Application by Highways England for an Order Granting Development Consent for the A303 Sparkford to Ilchester Dualling Submission made by Somerset County Council pursuant to Deadline 3 of the Examination Timetable

**PLANNING ACT 2008
APPLICATION BY HIGHWAYS ENGLAND FOR AN ORDER GRANTING DEVELOPMENT
CONSENT FOR THE A303 SPARKFORD TO ILCHESTER DUALLING**

Deadline 3 – Comments on the Draft DCO (Document 3.1 dated January 2019 – Rev C)

Deadline 3 – Comments on the applicant’s answers to First Written Questions

Drawing Number
HE551507 - MMSJV - LSI -
 000 - DR - UU - 2041
 Project Ref. No.
389107
 Revision
C03

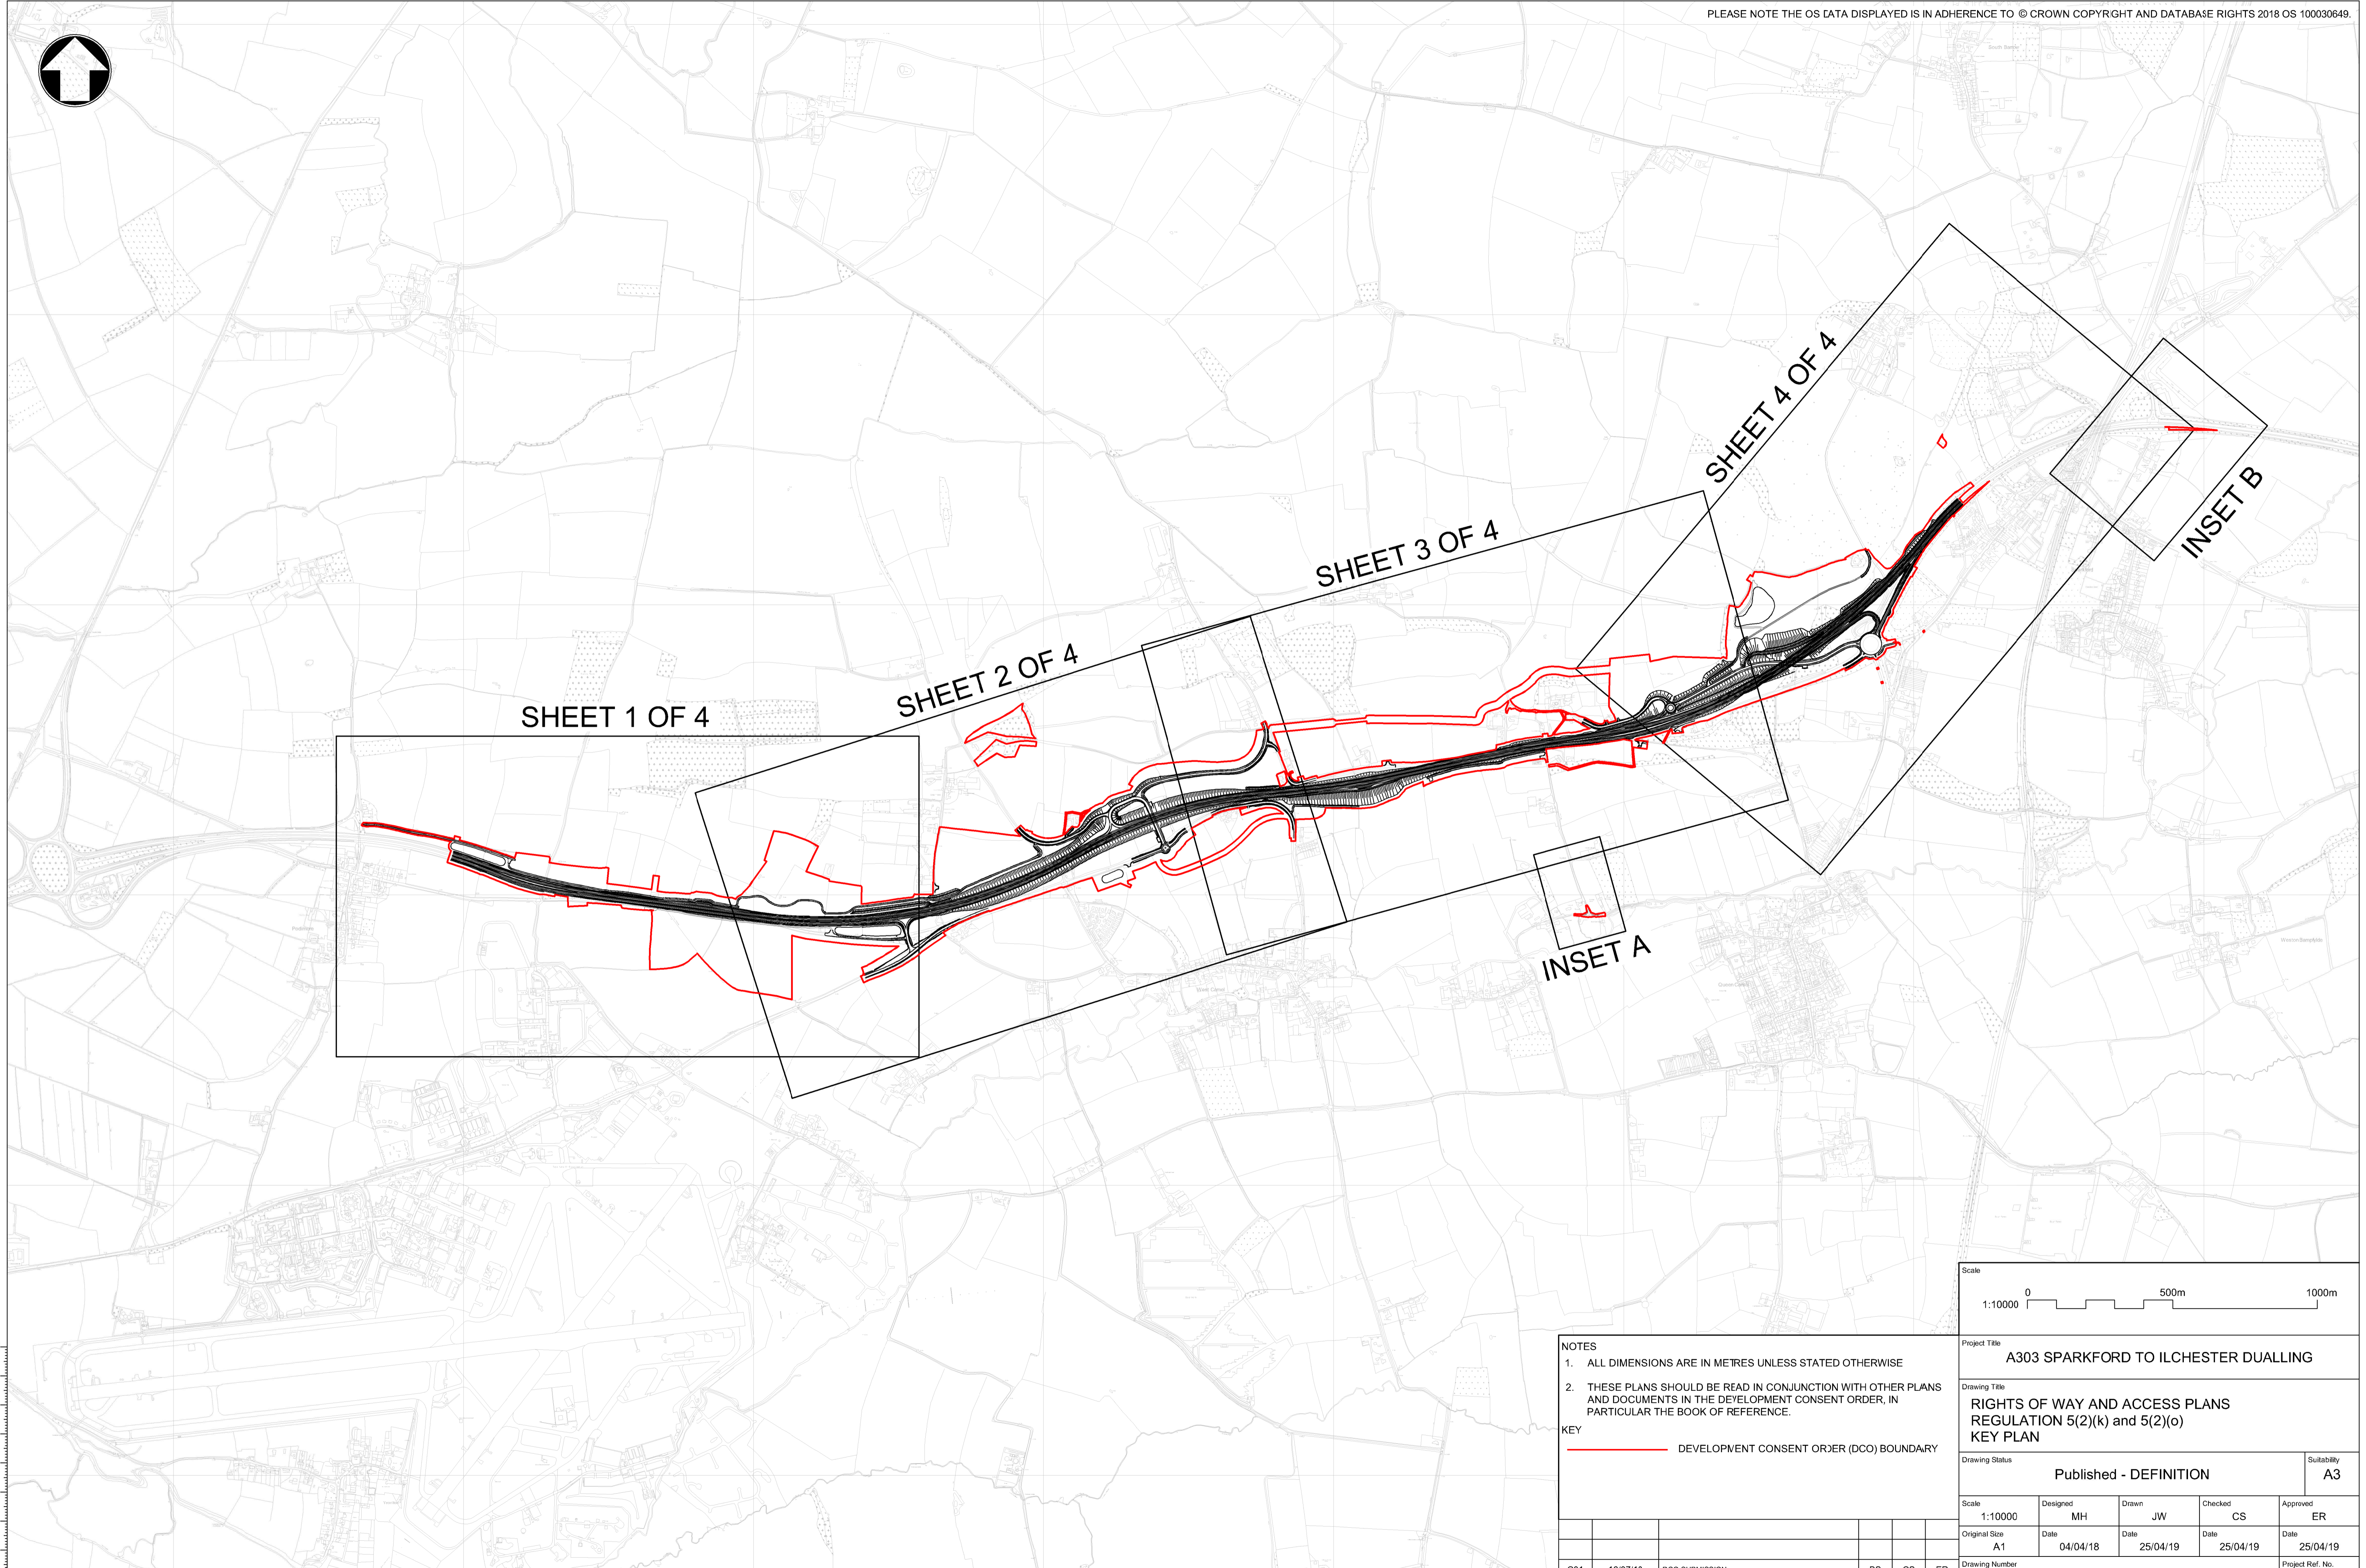
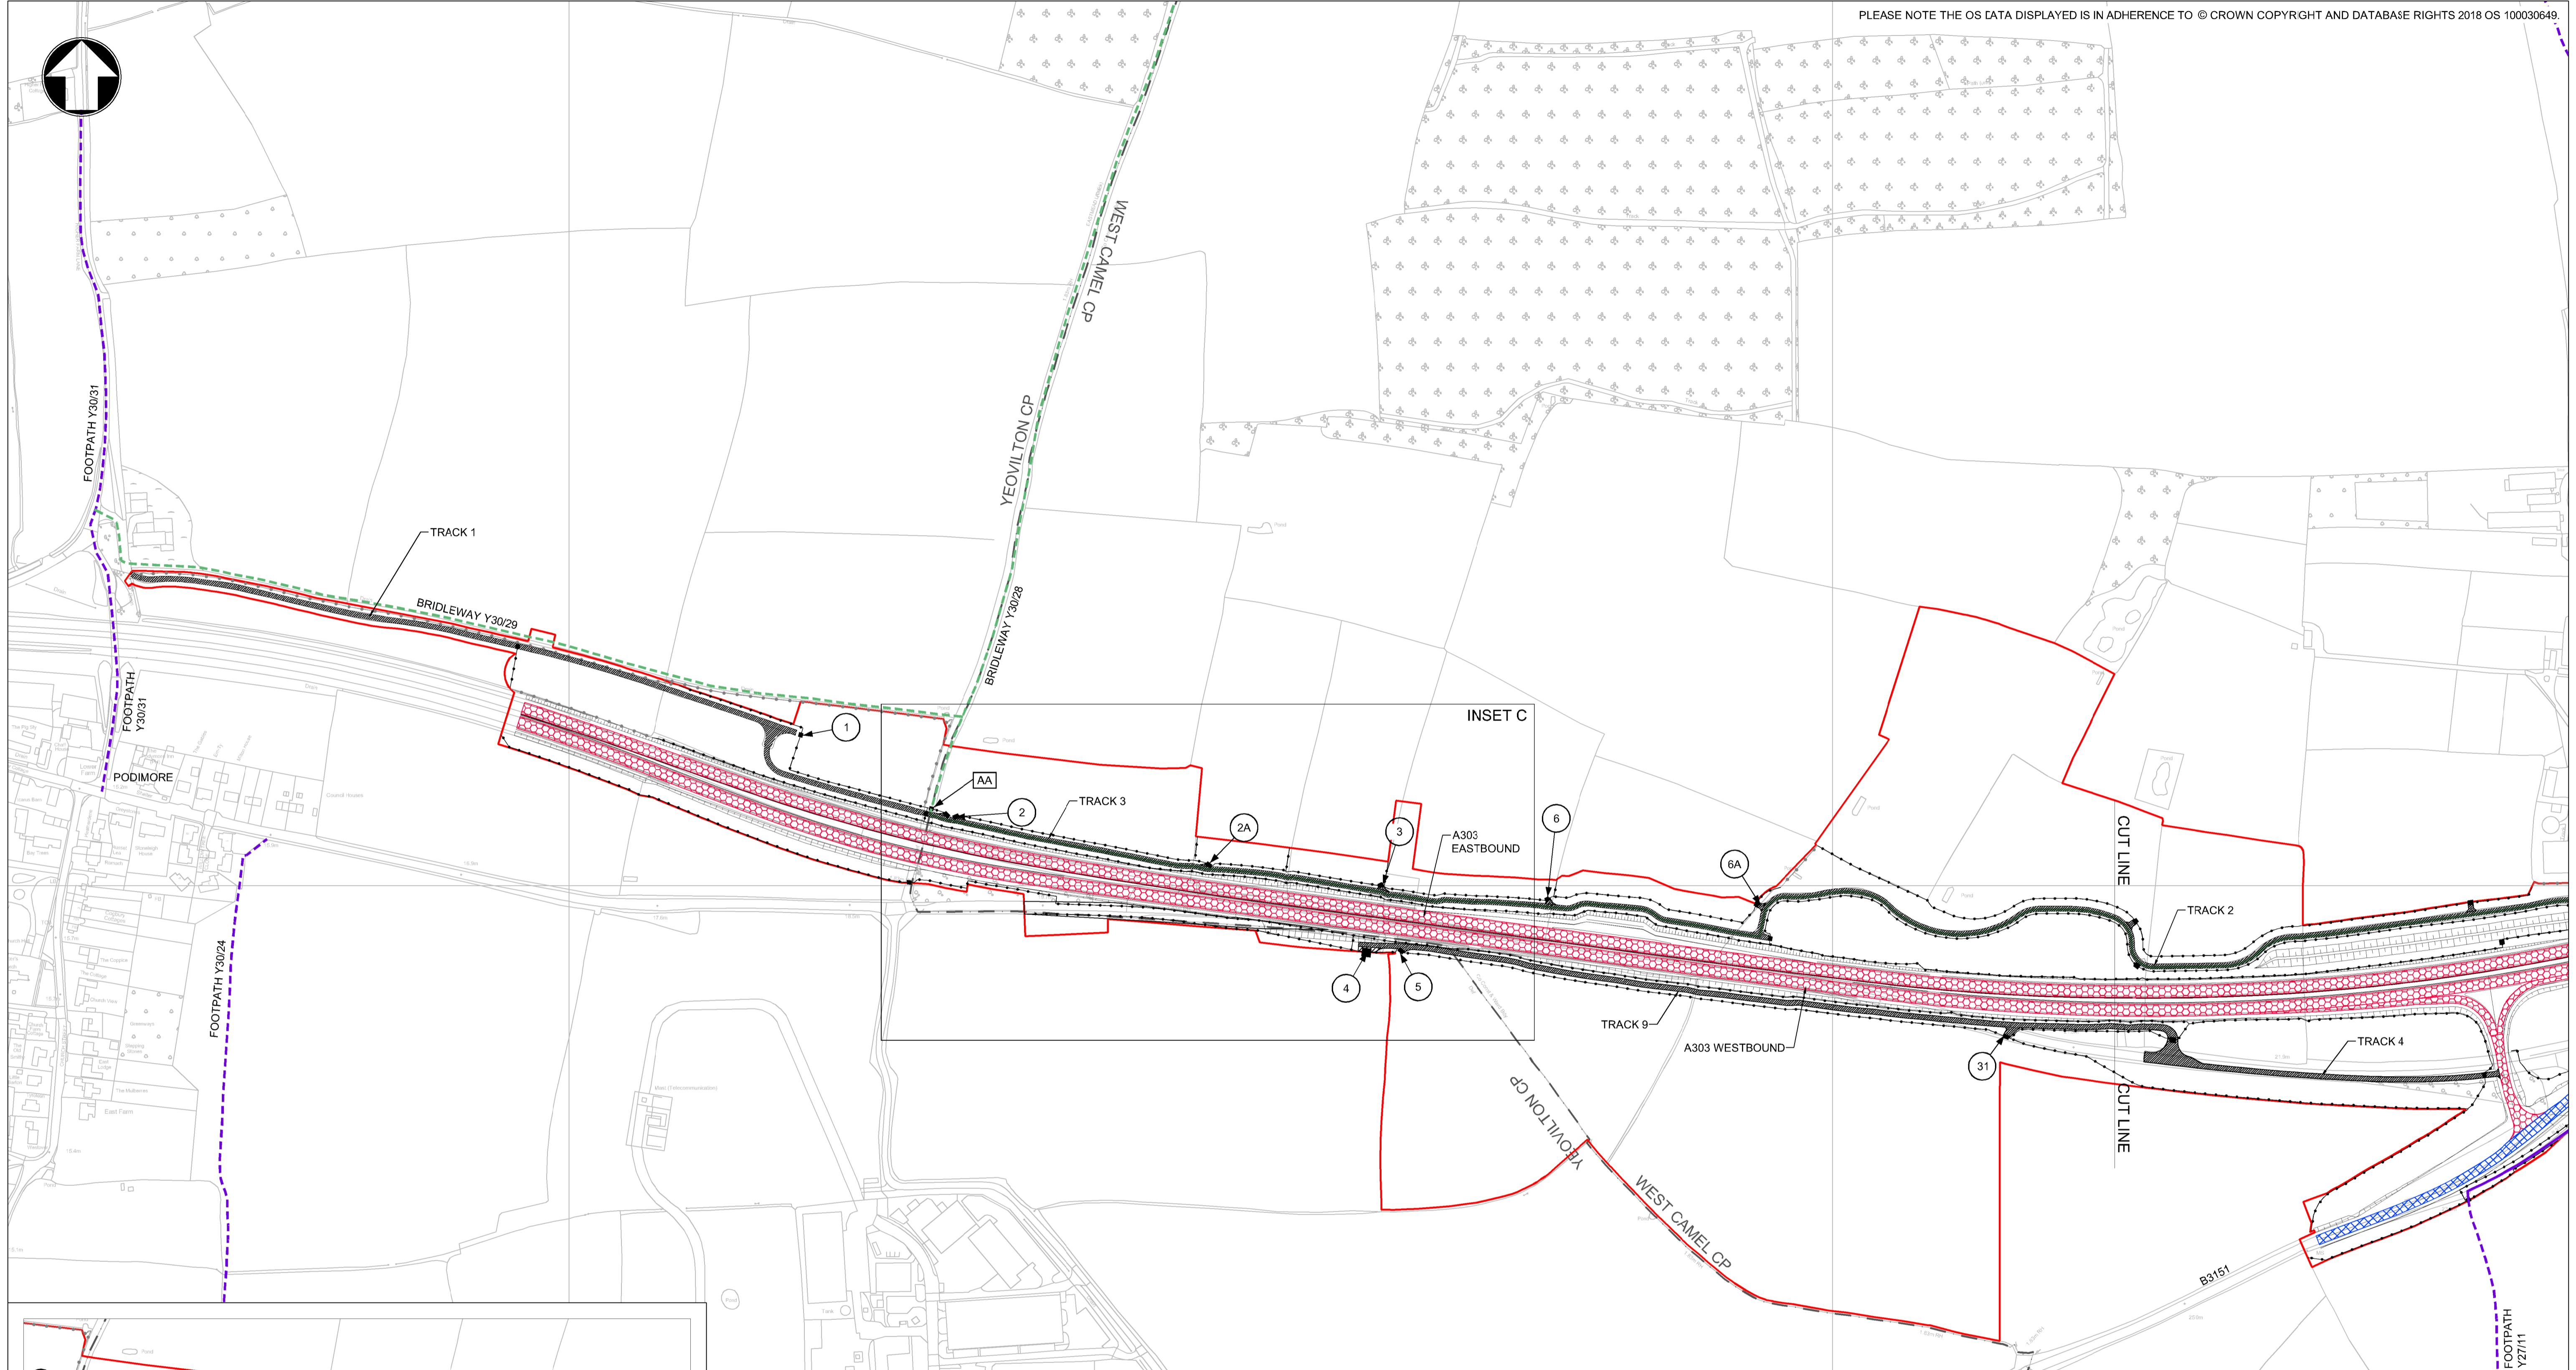
25.	<p>Schedule 3 Classification of Roads and 4 Highways to be stopped up</p>	<p>Several amendments have been identified in the LIR in relation to the rights of way provisions.</p> <p>Typographical errors:</p> <p>1) Omission of path sections from DCO (Sheets 3 & 4 Rights of Way & Access Plans) AW-AY, AZ-BA-BB-?, BZ-CA-CB-CD-?, BL-BK, BD-BY-BN, BY-BE has been omitted from these Schedules</p> <p>2) Incorrect path status (Ref. Draft DCO Schedule 4 Part 2 & Schedule 3 Part 11. Sheet 4 Rights of Way & Access Plans.) BM-BN referenced as new bridleway. BO-BP referenced as new footpath. BN-BO omitted. BR-BS and BT-BU referenced as footway/ cycleway Amend DCO to reference BM-BN-BO-BP as new footpath. BR-BS and BT-BU - amend to bridleway or</p>
